Engineers Comments Regarding Surface Water Drainage

Application Reference:	CM/6/24/DOC	Reviewer Reference:	ADC/EXT12/GK
Planning Officer:	Jessica Riches	Date of Review:	01.10.2024
Site Name:	Land to the West of Church Lane and South of Horsemere Green Lane Climping		
Application Description:	Approval of details reserved by condition imposed under CM/1/17/OUT relating to conditions 6-Phasing Plan and Programme , 8-Arboreal Method Statement, 9-surface water drainage scheme, 10-discharge of flows to watercourses or the culverting, diversion, infilling or obstruction of any watercourses on site , 11-Flood Management and Mitigation scheme, 12-Ecology Management and Mitigation Plan, 13-archaeological works, 14-Constuction Method Statement, 15-Travel Plan, 16-energy efficiency measures, 17-acoustic barrier, 21-Employment and Skills Plan and 22-provision of broadband.		
Assessment Number:	2 of 2

NoApplication Reference: CM/6/24/DOC	Initial Issue Date:
Site Name: Land to the West of Church Lane and South of Horsemere Green Lane Climping	Issue Date: 02/01/2024
	Reviewer Reference: ADC/EXT12/GK

Drawing Code Drawing No. Rev.
000-BPC-WD-ZZ-D-C C401 -

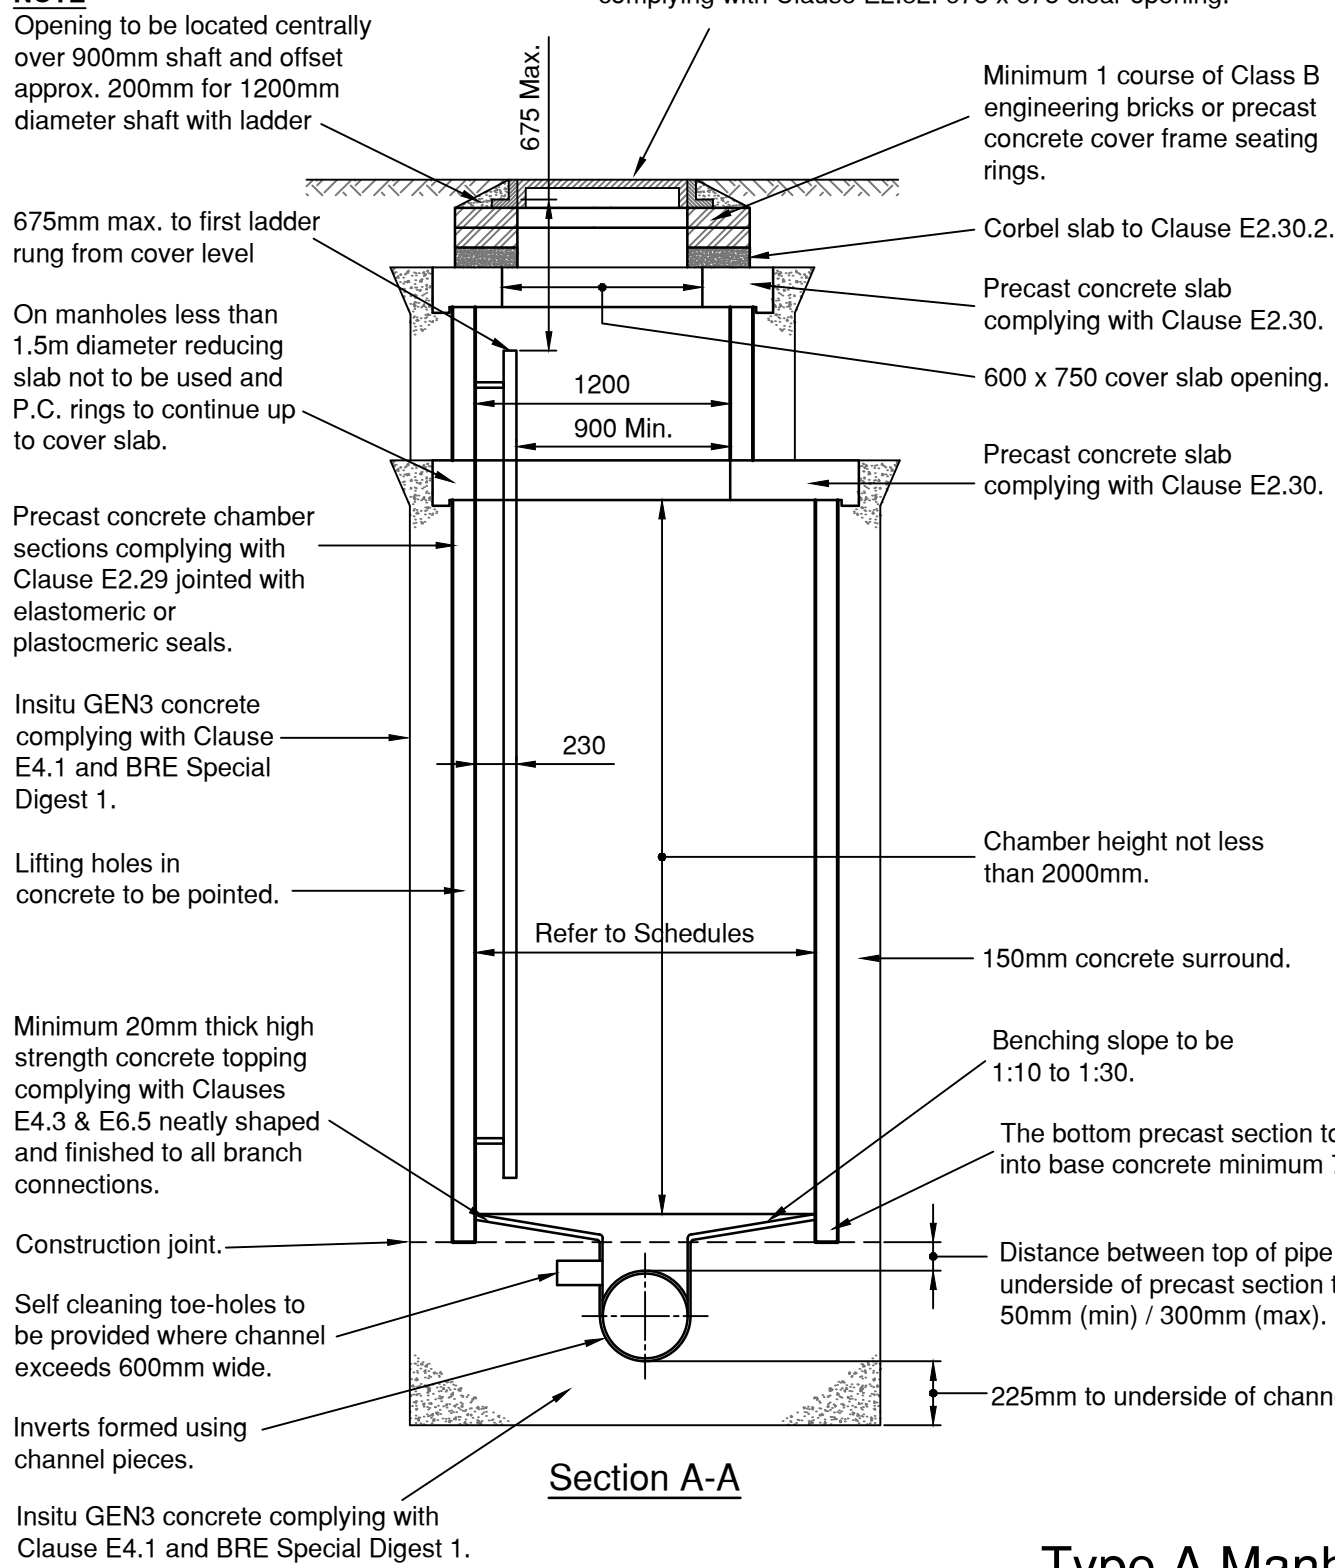
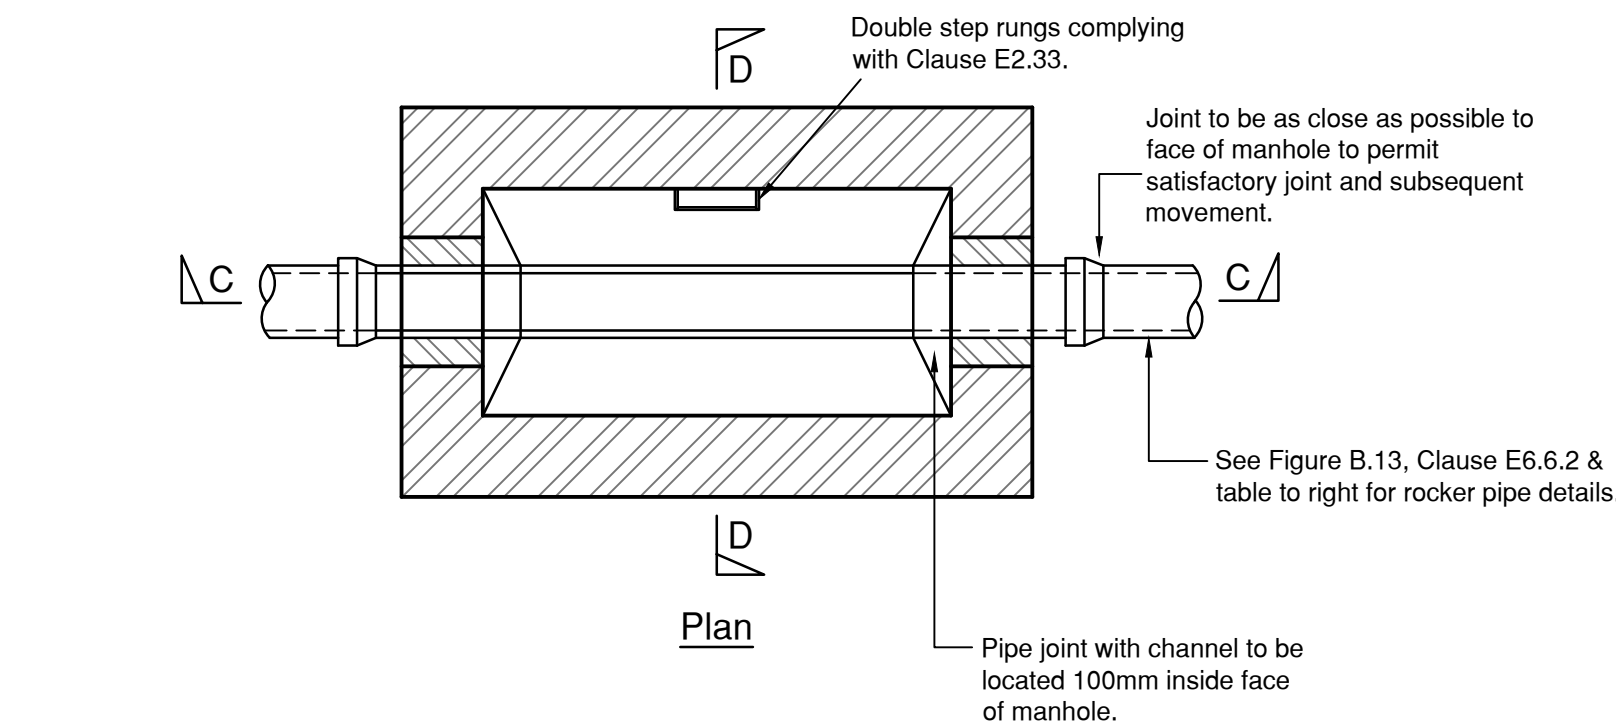
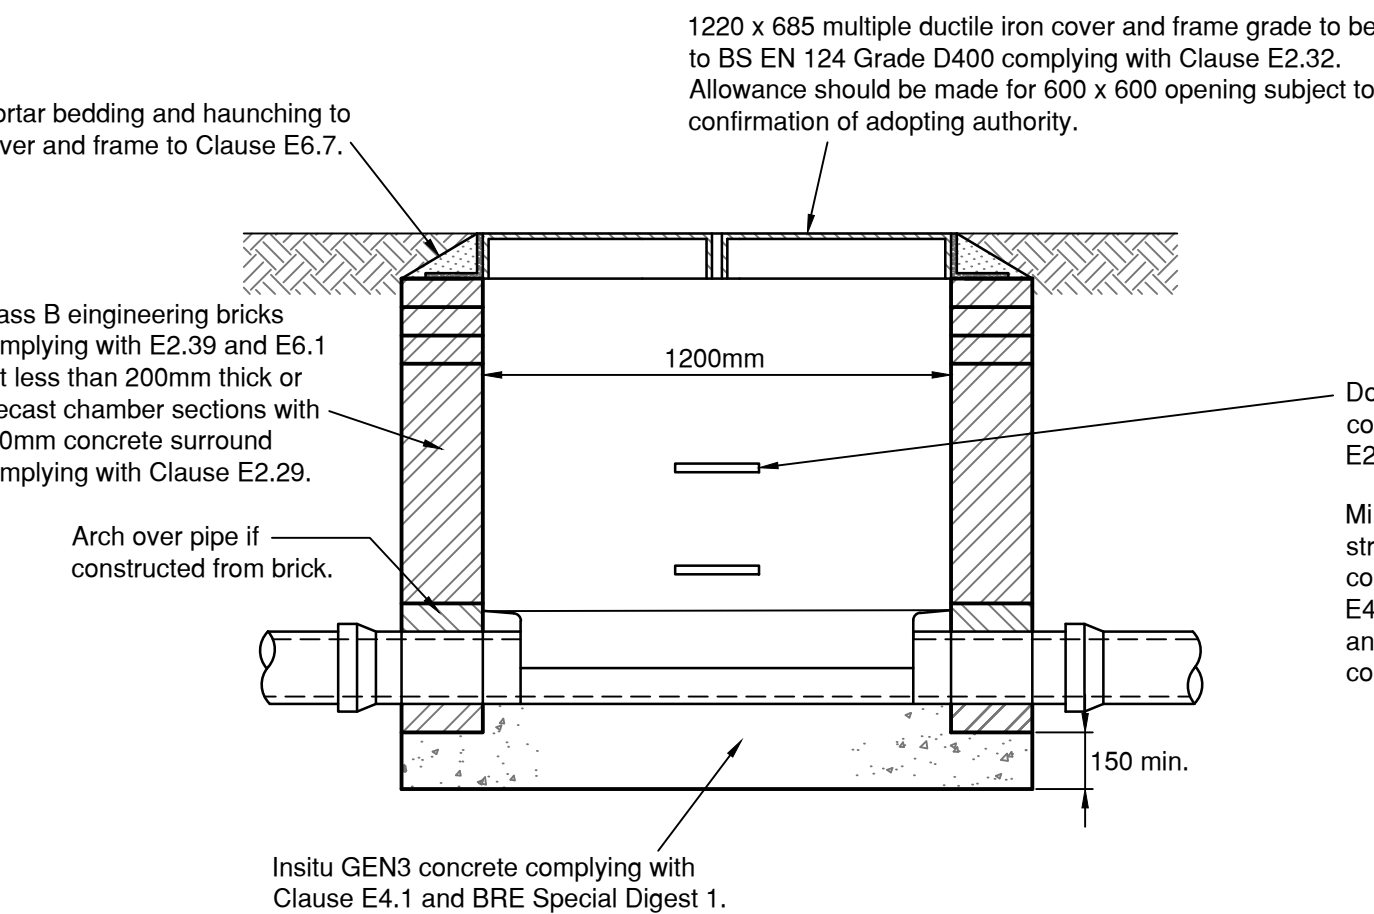
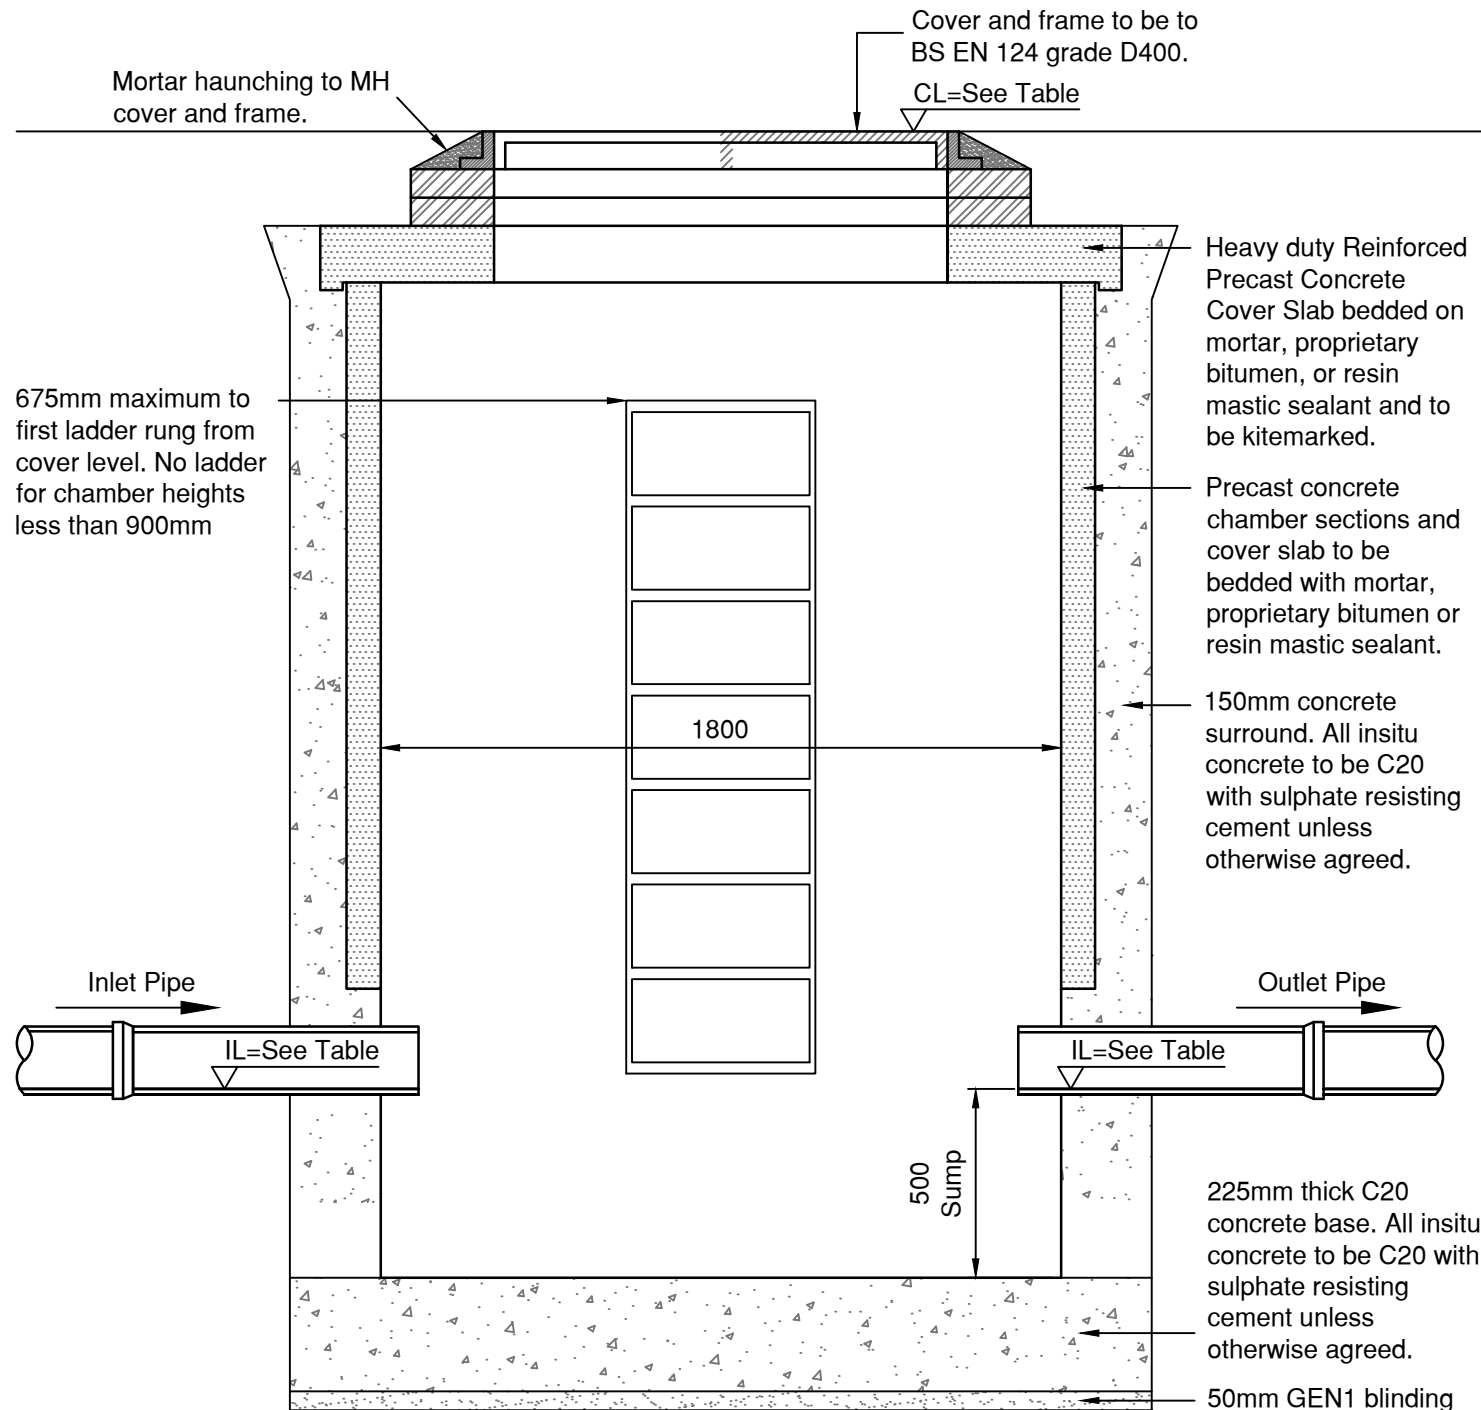
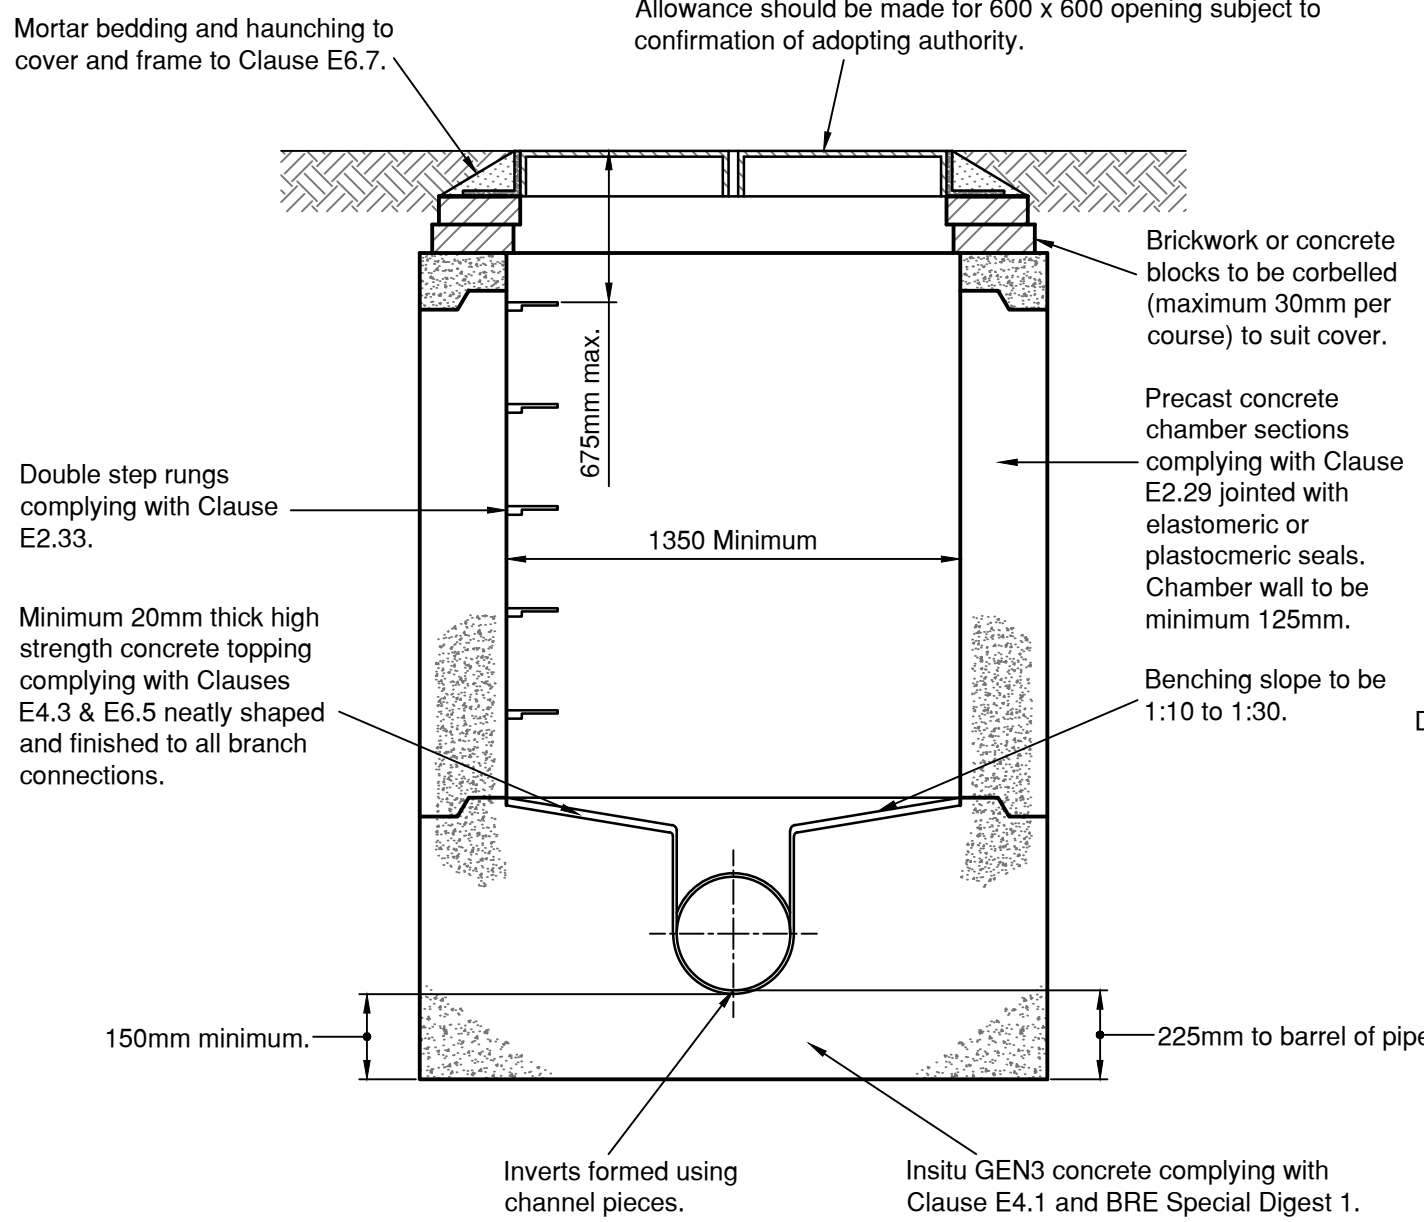
12.	No manhole schedules have been provided.	No comments – refer to updated design.	Manhole schedule submitted but many manholes are missing probably due to wrong printing options. All the manholes are shown as Type E which is impossible. Please also note which manholes are catchpits. All the manholes have a diameter of 450 which is wrong in many cases. Please amend. Please specify the cover type on manhole schedule. Clarify how the shallow pipes will be protected.	The schedules (domestics FOR-E5139-419 and mains FOR-E5139-415 to 418) give information on manholes. Information on all private drainage is not given as this is subject to change on-site during construction and to offer the groundworker a level of flexibility. These refer to the inspection chambers, manhole types have been removed for clarity (as they are not applicable) - FOR-E5139-419 These refer to the main inspection chambers for the private drainage. Refer to table on plan regarding cover types - FOR-E5139-415 to 418 Pipes shall be protected in accordance with pipe bedding details (FOR-E5139-474). Where minimum cover cannot be achieved, pipes shall be protected via a concrete slab.
